TfNSW Reference: SYD24-01760/07

DPHI Reference: SSD-76927247

**THE TIMBERYARDS BY RTL CO - MOD 1
VICTORIA ROAD, SYDENHAM ROAD, FARR STREET, AND MITCHELL STREET, MARRICKVILLE**

**RESPONSE TO SUBMISSIONS - THE TIMBERYARDS BY RTL CO.
VICTORIA ROAD, SYDENHAM ROAD, FARR STREET, AND MITCHELL STREET, MARRICKVILLE**

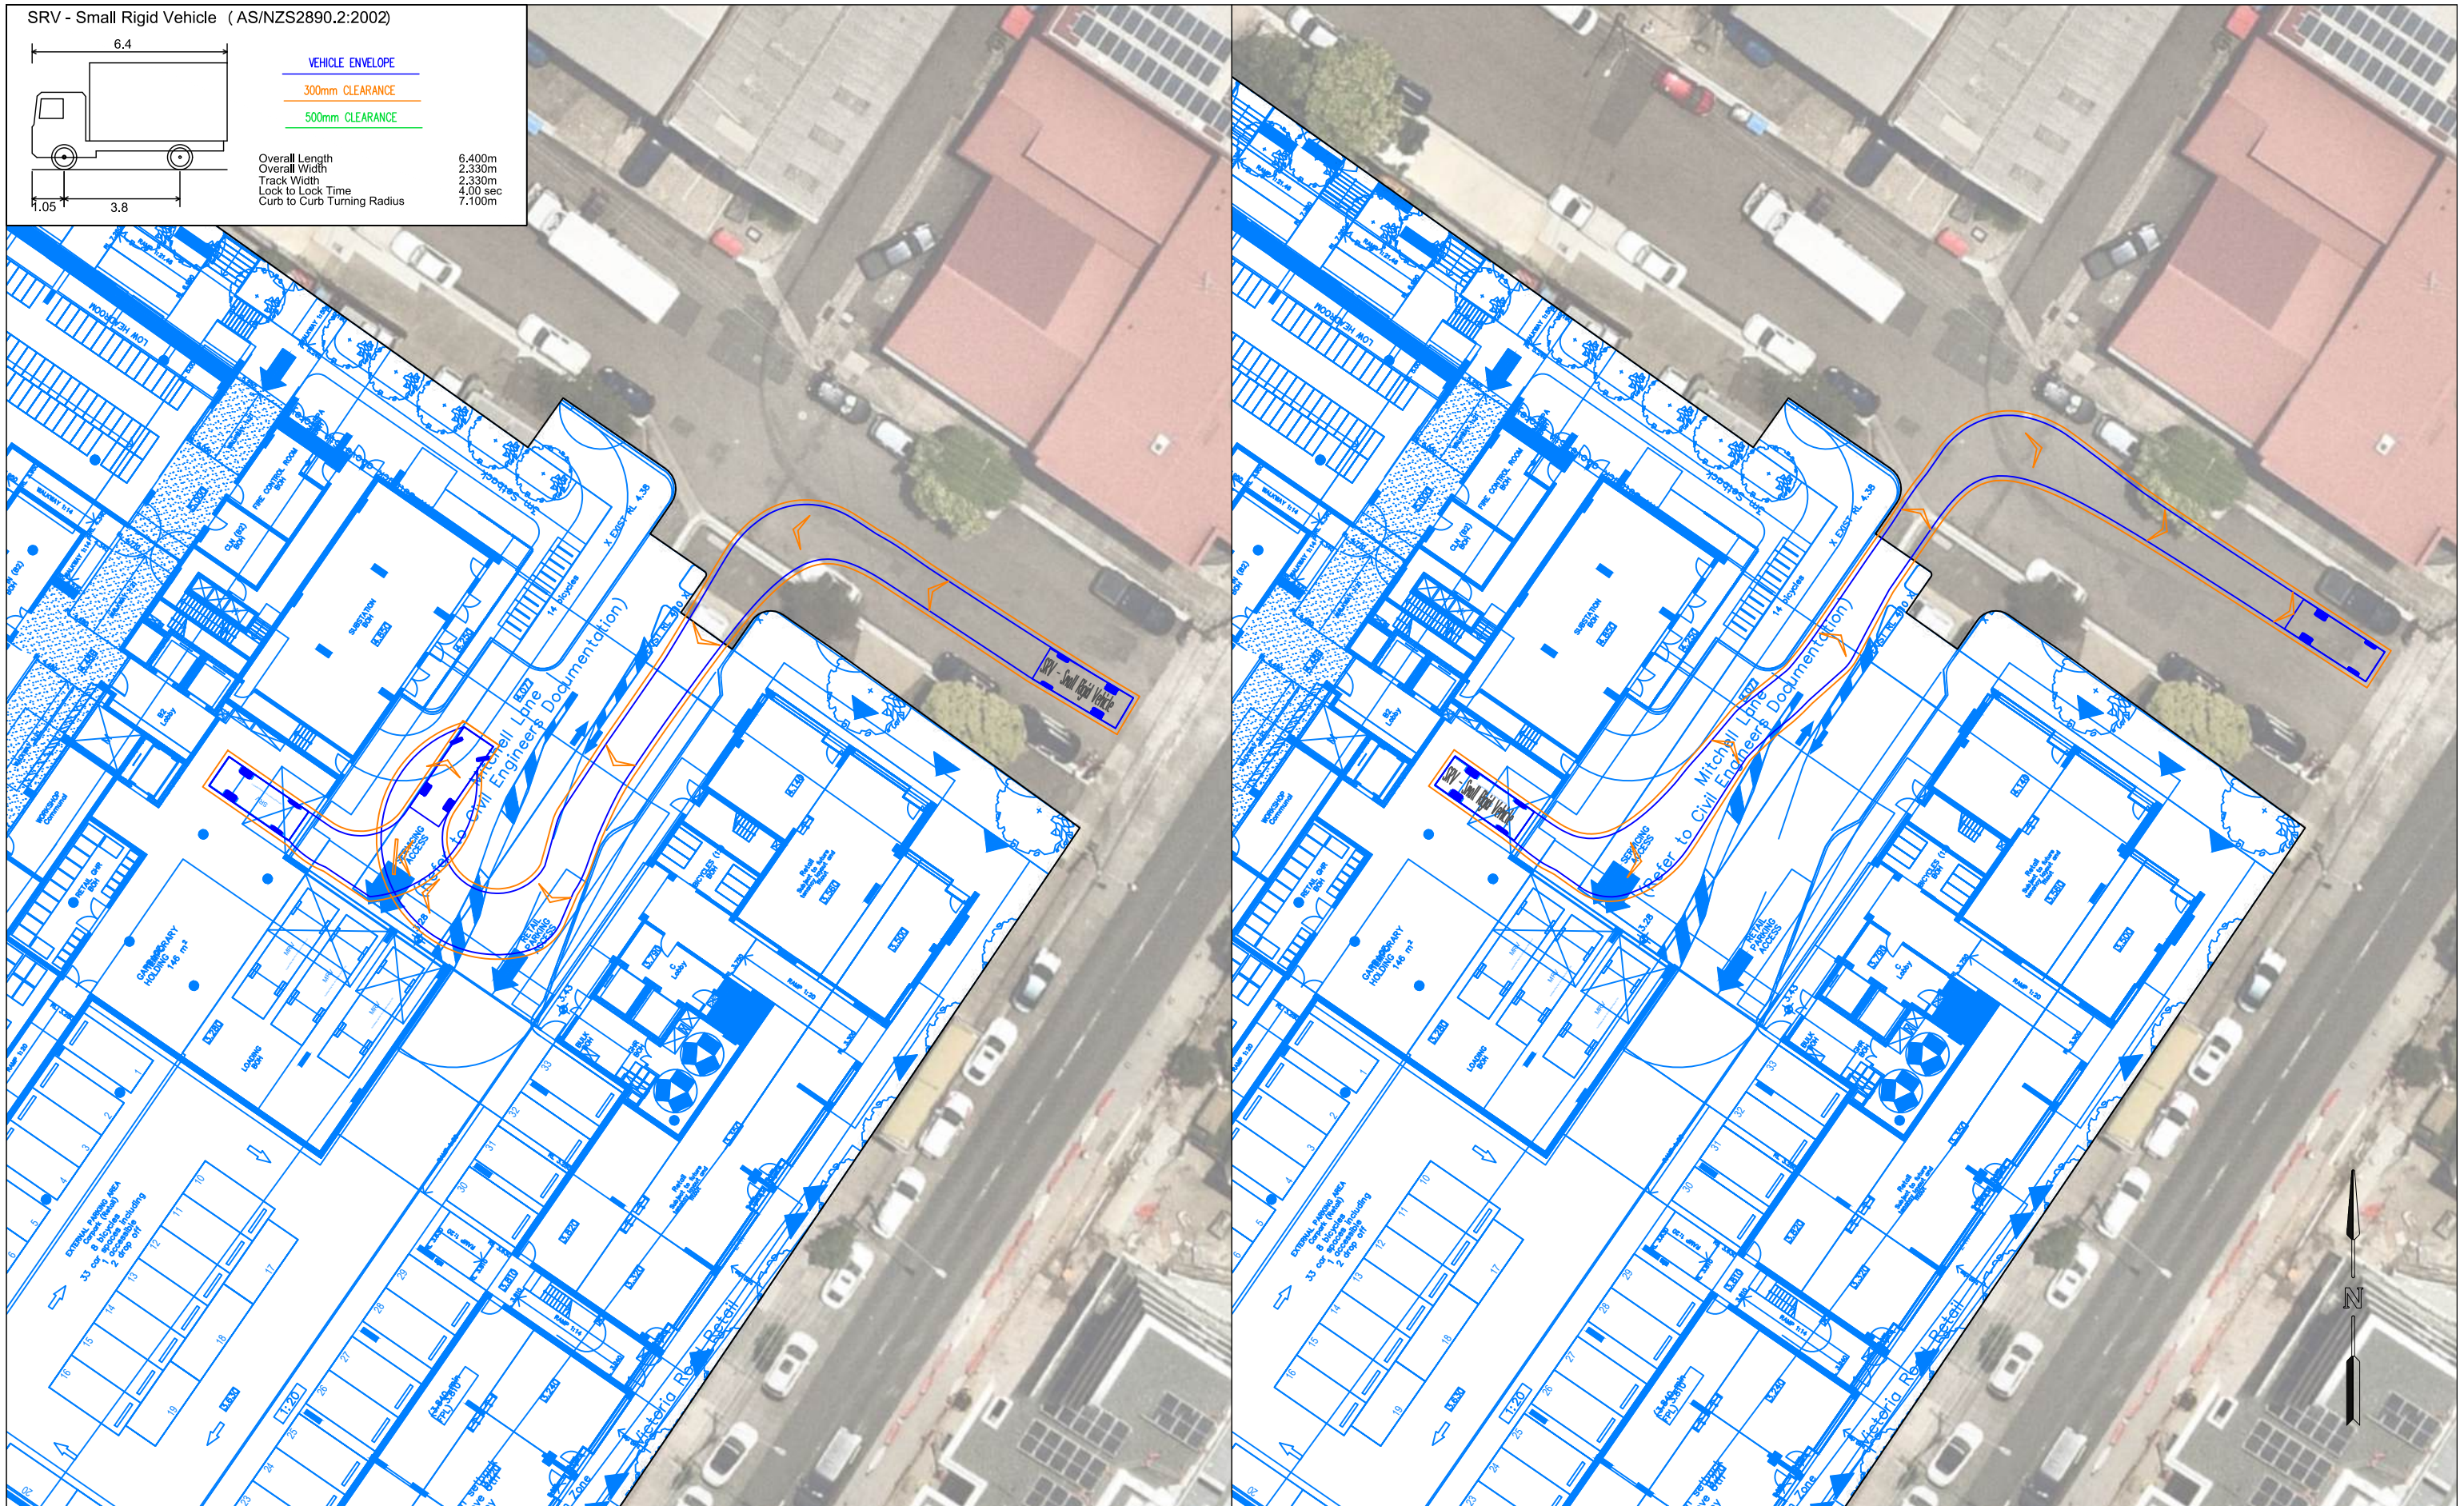
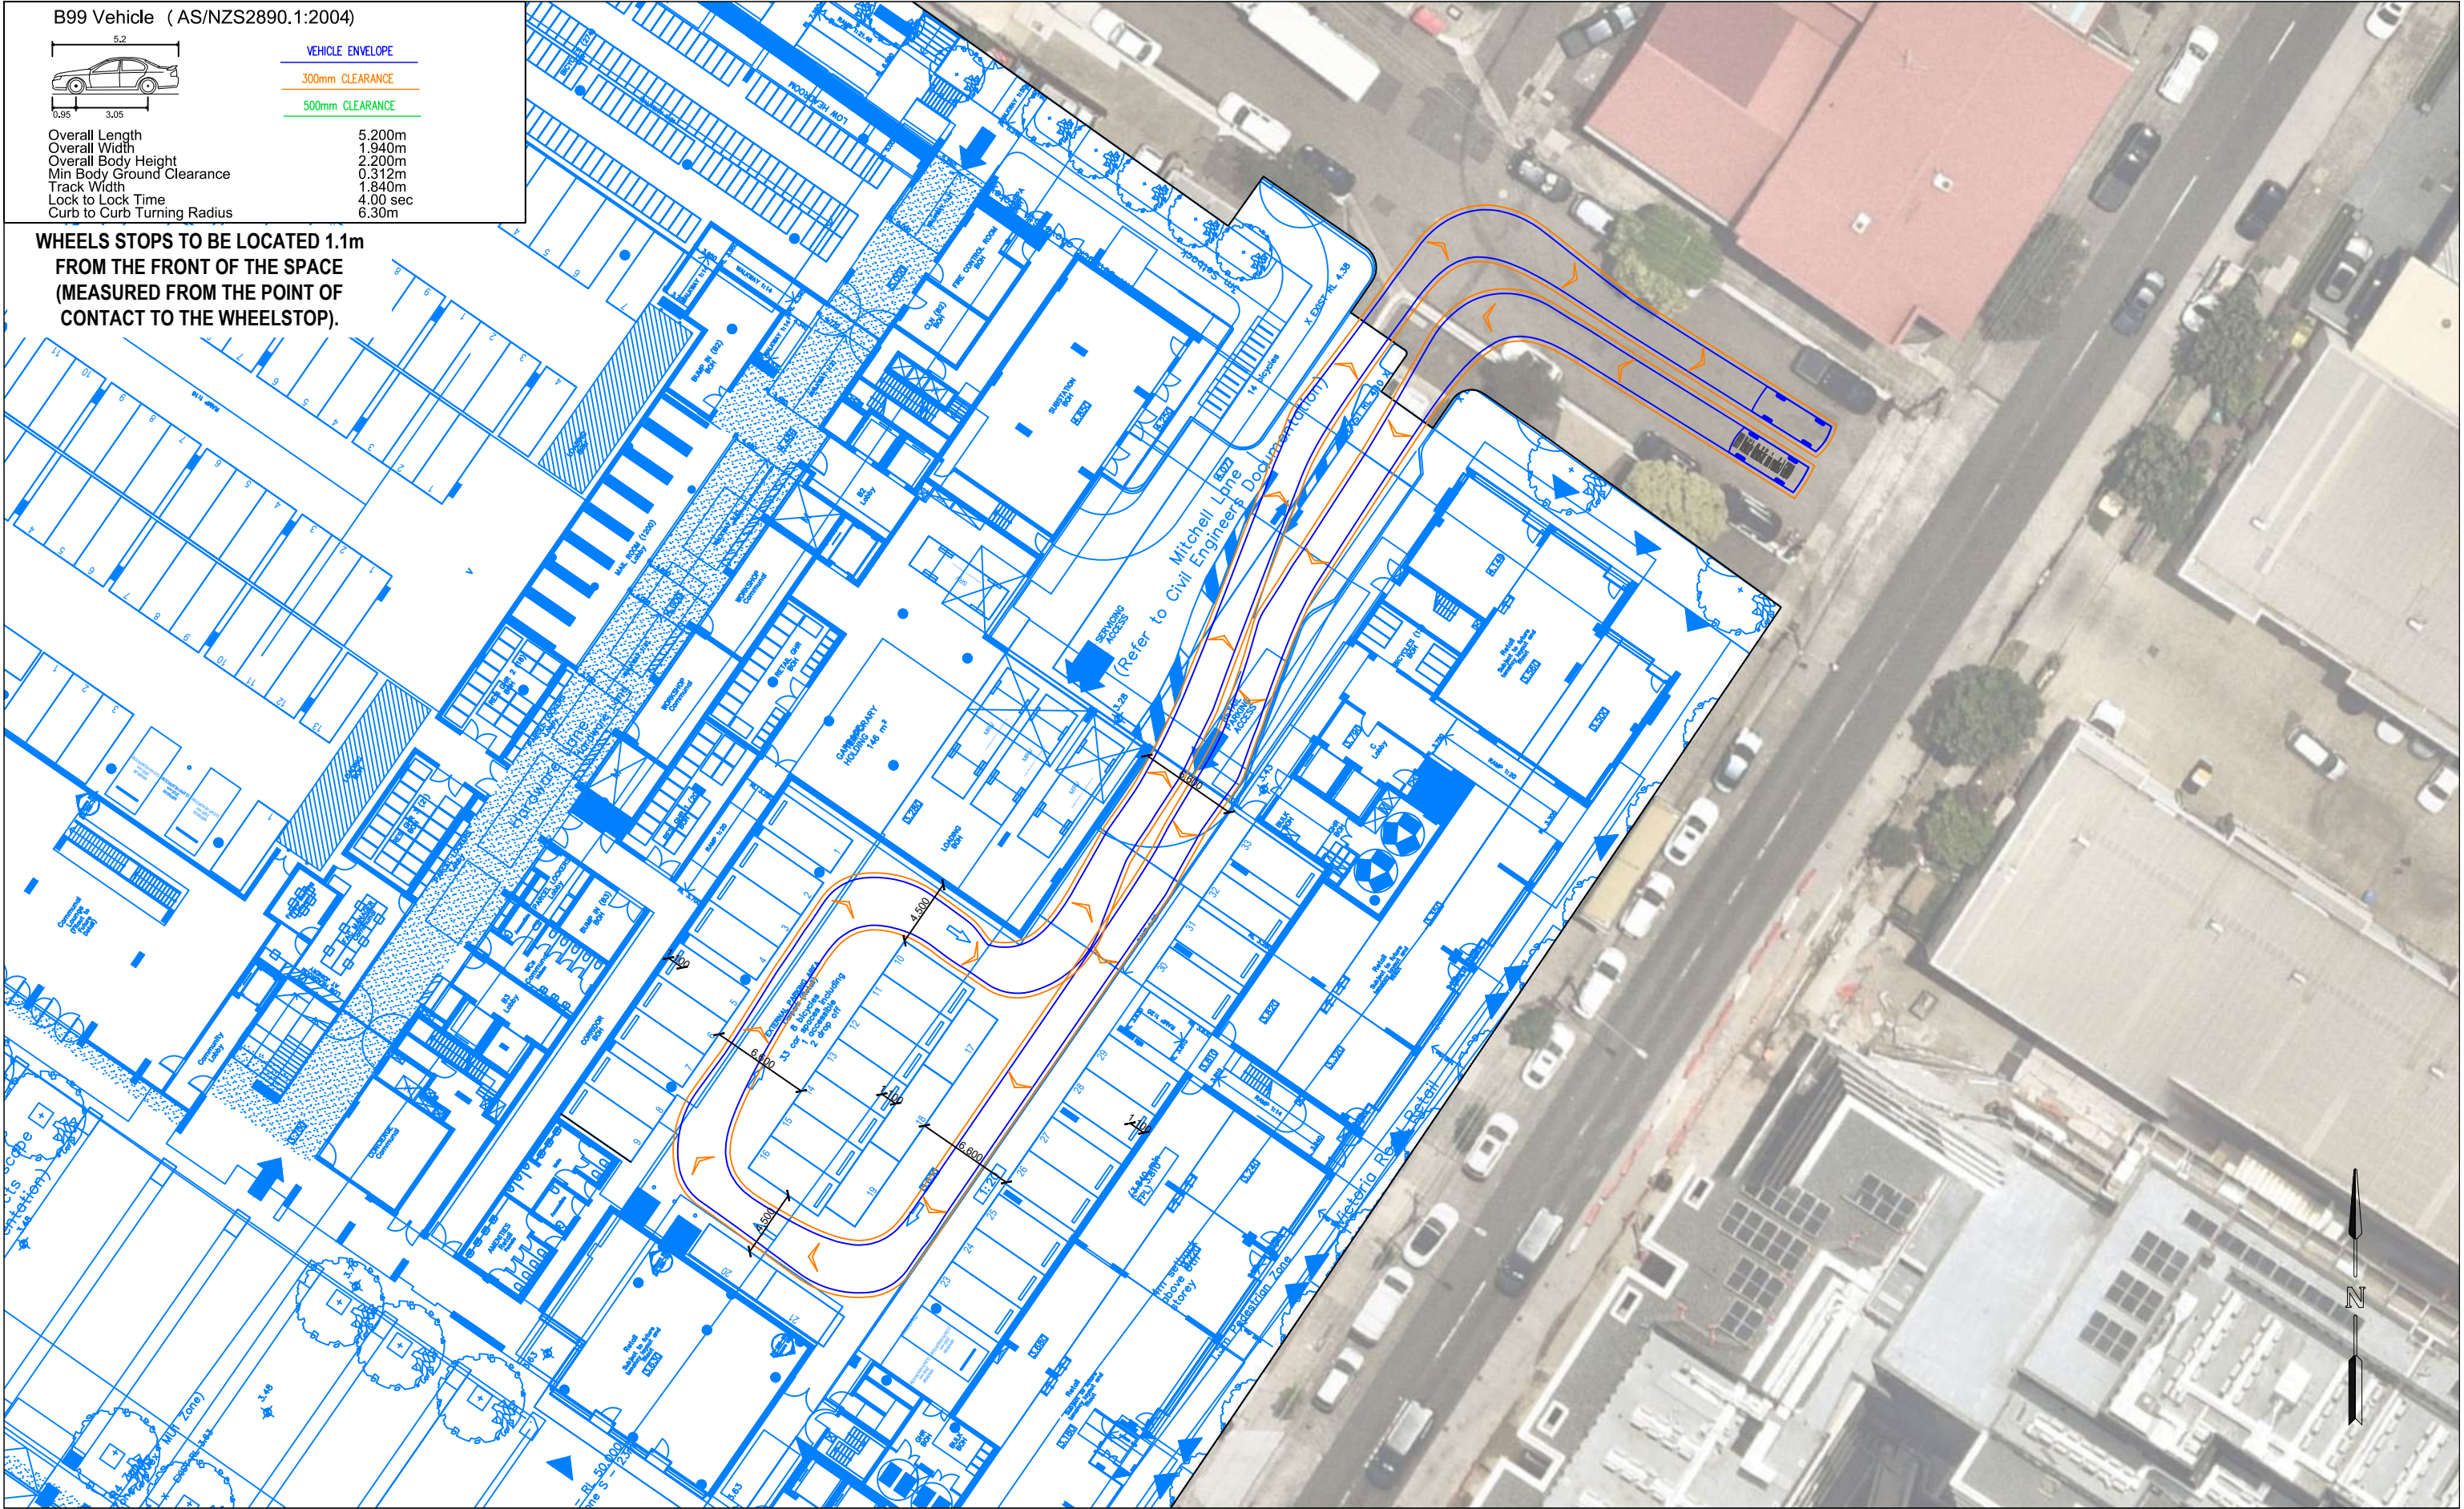
- a) A 12.5m long Heavy Rigid Vehicle (HRV) appears to require the use of the majority of the width of Mitchell Street to access the site, such that another vehicle would not be able to wait to turn out of Mitchell Street while the HRV turns left into Mitchell Street. In consultation with Council, DPHI may wish to consider whether there is a need to include a condition of consent requiring the installation of 'No Stopping' signage for an appropriate length on Mitchell Street, adjacent to the intersection with Victoria Road, to provide space for access by HRVs.
